Recommendation Report for Planning Permission for Works or Extension to a Dwelling

REF NO: R/88/22/HH

LOCATION: Chudleigh
The Close
Rustington
BN16 2DW

PROPOSAL: Erection of part single, part two storey rear and single storey front porch extension with terrace, hip to gable roof extension with solar panels and installation of timber cladding in place of hung tiles to bays.

Drawing Name: Ground Floor as Proposed

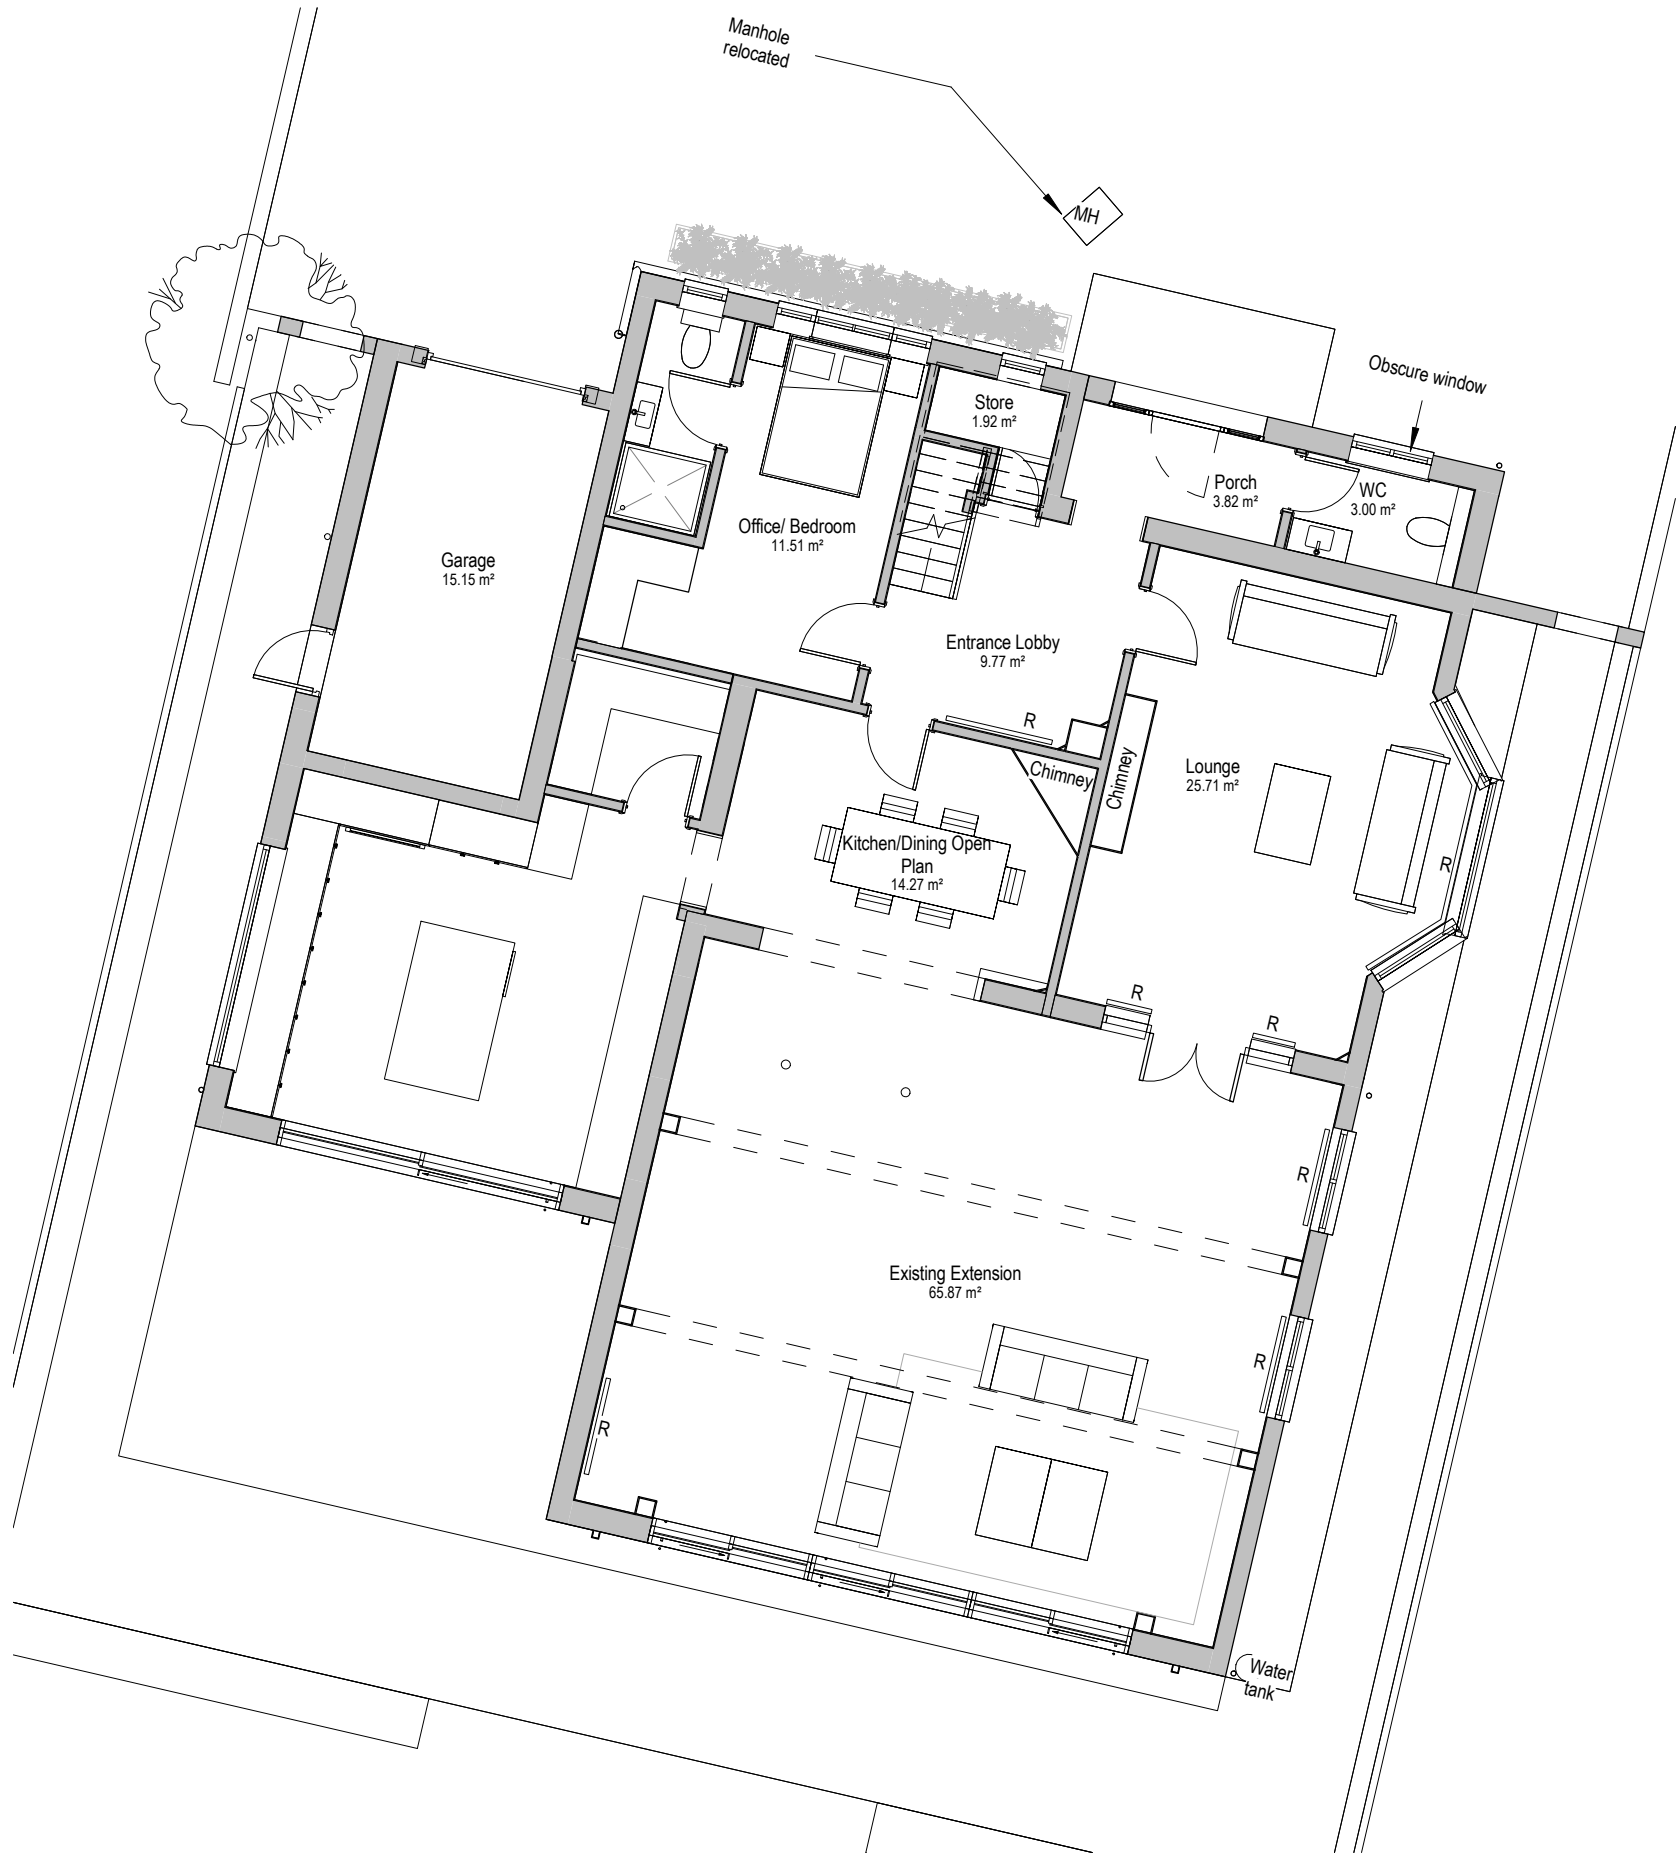
It is proposed to demolish an existing conservatory and replace it with a part two-storey, part single-storey rear extension, including a roof terrace. A new front porch addition is also proposed. The rear extension will be approx. 5m deep and 5.6m wide at ground floor level and only 1.3m deep at first floor. The porch will measure approx. 3m in width by 1.3m deep and have a pitched roof configuration. As the extensions do not change the nature of the property the spatial composition of the site will not be compromised.

The plot on which the host dwelling sits has a semi-open frontage, as such the porch will be highly visible from the street and will affect the character of the area. By reason that the proposed extension is built of matching materials, utilises complementary design features which affords it good visual integration with the host dwelling, and is to be built to an appropriate scale, then it will not have an unacceptable detrimental effect on the character of the area.

The rear extension and works to the roof will be located a minimum of 1.3m away from the western boundary and the front extension will be 2.5m away from the eastern and 9.2m set back from the road. The minimum separation gaps between respective boundaries will not be diminished below existing site conditions and a rear garden length above design guidance recommended levels will be retained. The 45-degree rule is not applicable for this rear extension as the property sits adjacent to neighbours fronting Sea Avenue (at a 45-degree angle to the host dwelling). Given the extensions position, adjacent to the substantial rear gardens to the properties on Sea Avenue, the rear and roof additions will not overbear or overshadow them.

All other windows either face towards the front or rear private amenity space, at ground floor level where it is generally accepted that no harm will arise from overlooking.

P010 Roof Plan as Proposed

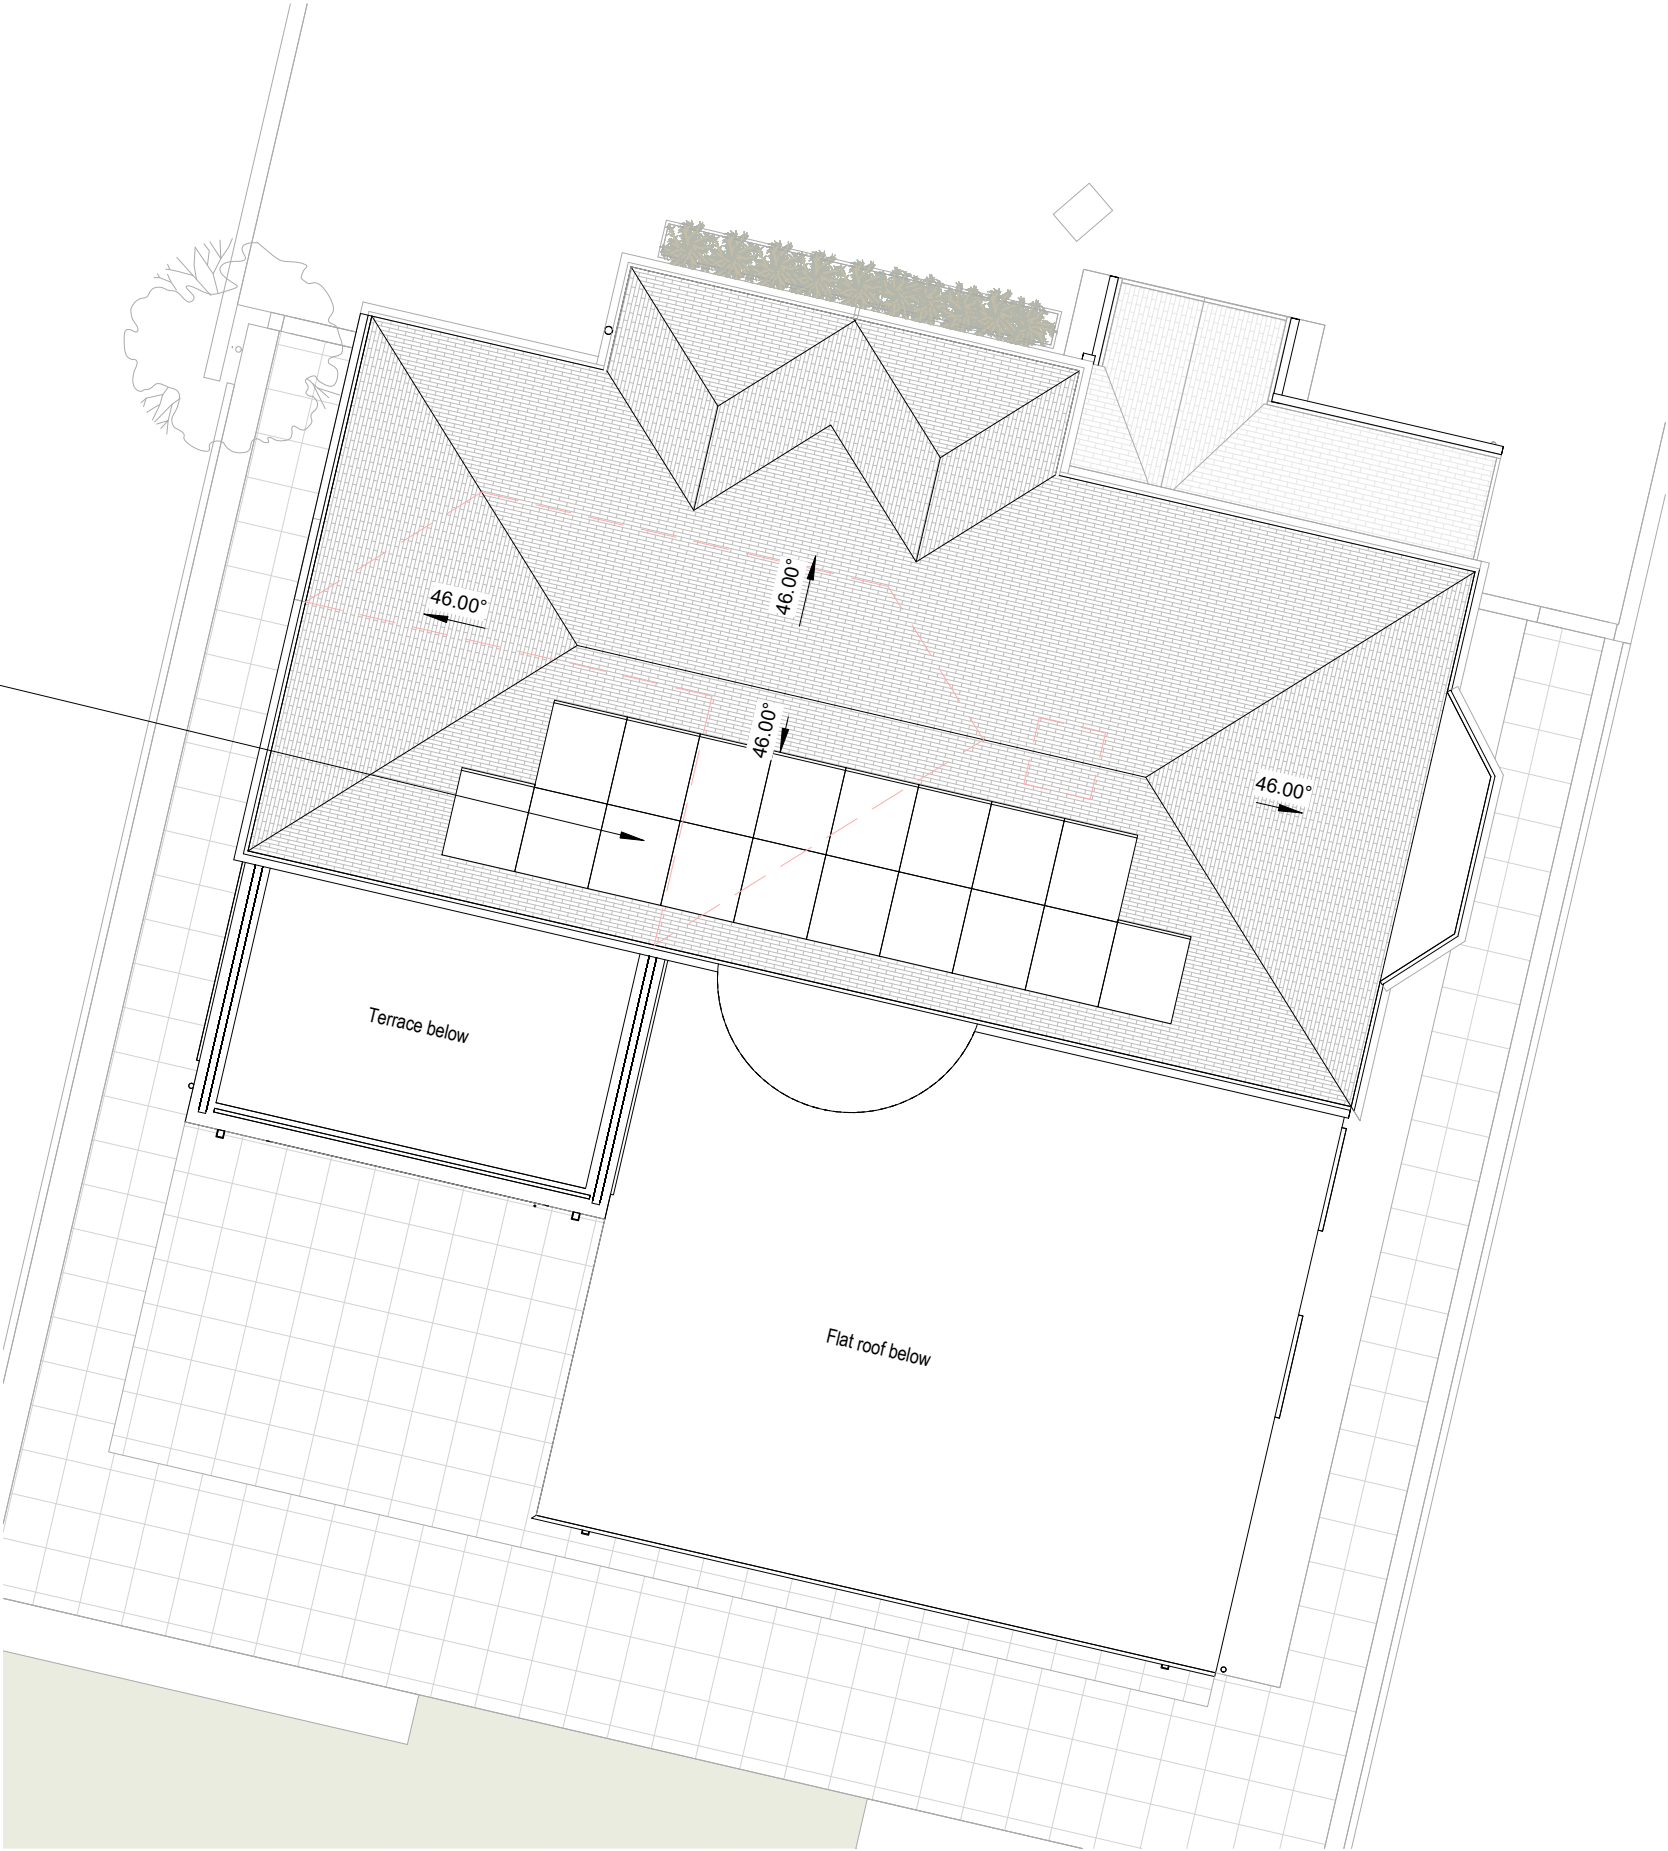
In addition to this it is proposed to add a hip to gable extension to the western elevation, which will affect the character of the building. The roof extension will not increase the ridge height or alter the eaves level, it will however encompass an existing portion of flat roof at first floor level. It is seen to give balance to the roof and incorporate less visually attractive parts of the existing structure. As such it will not negatively impact the character of the area and will be subservient to the host dwelling.

The alterations to the roof will facilitate the installation of solar roof panels. The inclusion of these panels accords with Policy ECC SP2 and do not detract from the scheme or harm the character of the building or area, by reason that they are subservient in scale and would be afforded approval under Permitted Development Rights.

P011 Proposed North and South Elevations

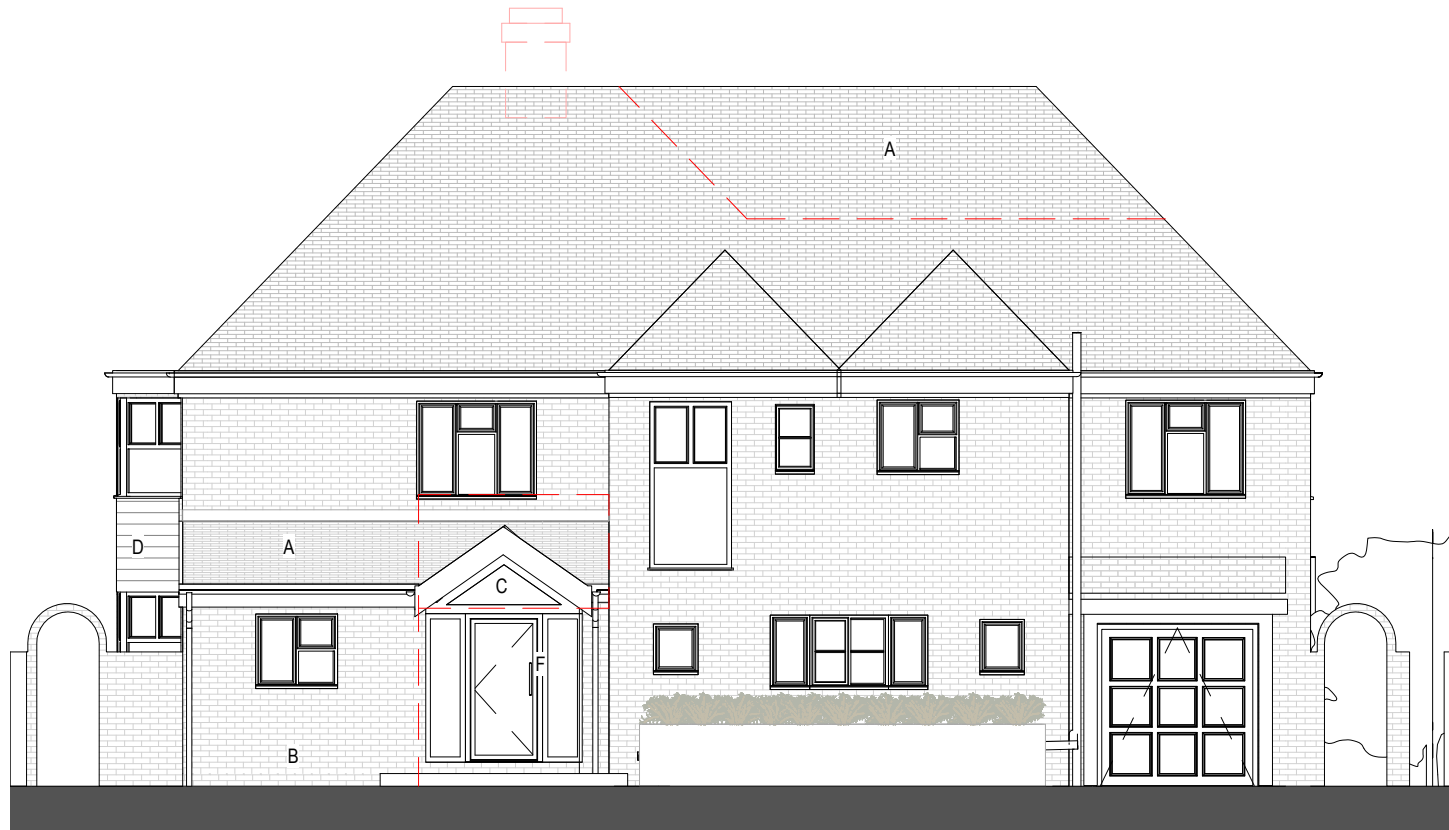
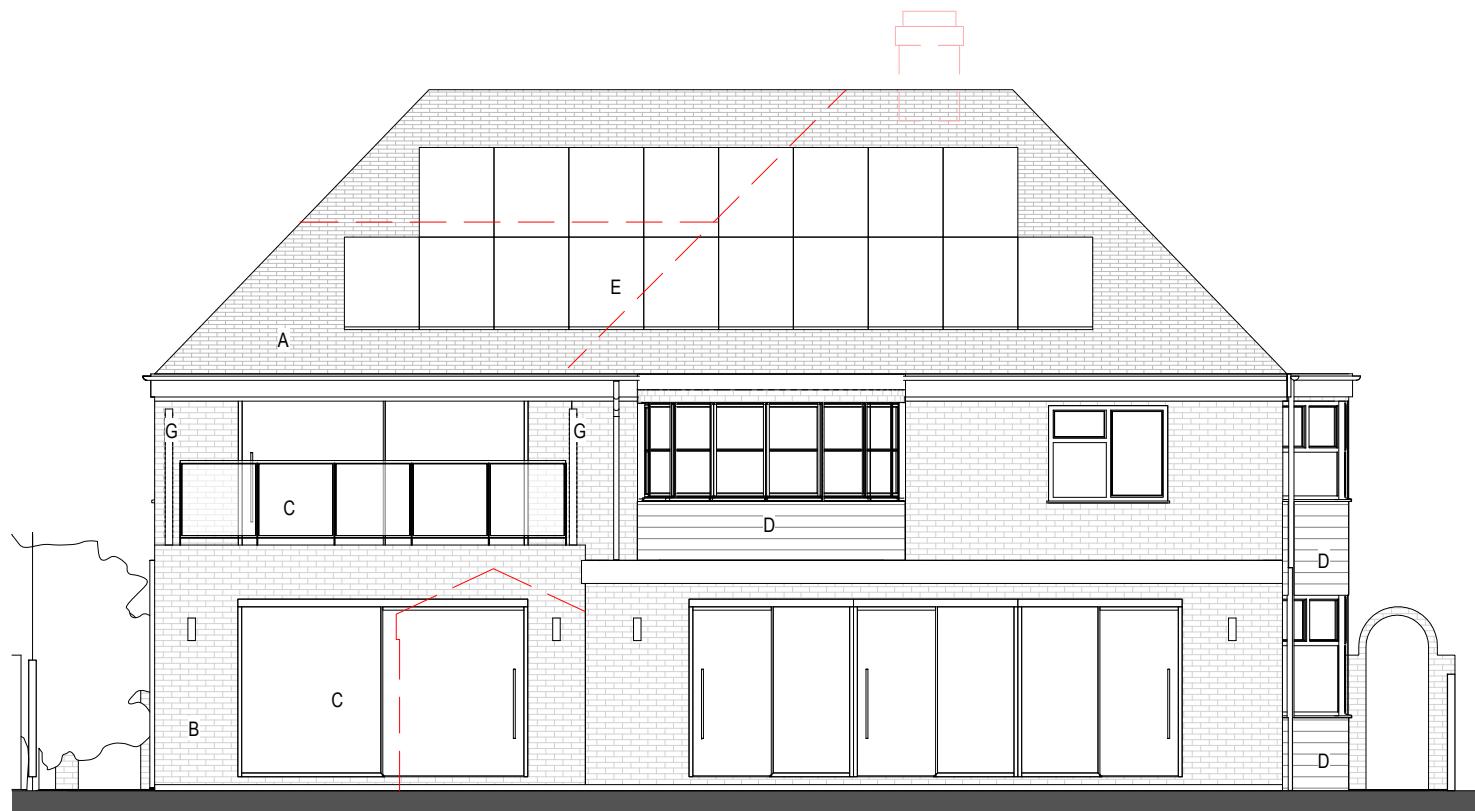
The rear extension by reason of its orientation to the rear of the property and mature boundary planting will not be visible. The first-floor extension will be built out in line with the existing southern elevation, it is only the ground floor extension which protrudes into the garden.

In terms of overlooking, new fenestration to be introduced at first floor level will face towards the rear private amenity space, where views are already achievable. A rear balcony is proposed, the two side facing elevations have been designed to have a minimum of 1.8m obscured screening. This is acceptable and will not negatively impact privacy levels to the properties to the east or west, a condition will be added to this approval to retain the screening in perpetuity.

- Location Plan P001
 - Proposed Ground Floor Plan P008
 - Proposed First Floor Plan P009
 - Proposed North and South Elevations P011
 - Proposed East and West Elevations P012
 - Proposed Block Plan P002
Reason: For the avoidance of doubt and in the interests of amenity and the environment in accordance with policy D DM1 of the Arun Local Plan.
- 3 The installation of side screening to the eastern and western faces of the approved balcony will be provided before the first use of the room and be built to a minimum height of 1.8m and shall be built using an fully obscured material, the screening shall remain at this minimum height and fully obscured in perpetuity.

Reasons In the interests of the amenities of the occupants of nearby properties in accordance with policies D DM1 of the Arun Local Plan.
- 4 **INFORMATIVE:** Statement pursuant to Article 35 of the Town and Country Planning (Development Management Procedure)(England) Order 2015. The Local Planning Authority has acted positively and proactively in determining this application by assessing the proposal against all material considerations, including planning policies and any representations that may have been received and subsequently determining to grant planning permission in accordance with the presumption in favour of sustainable development, as set out within the National Planning Policy Framework.
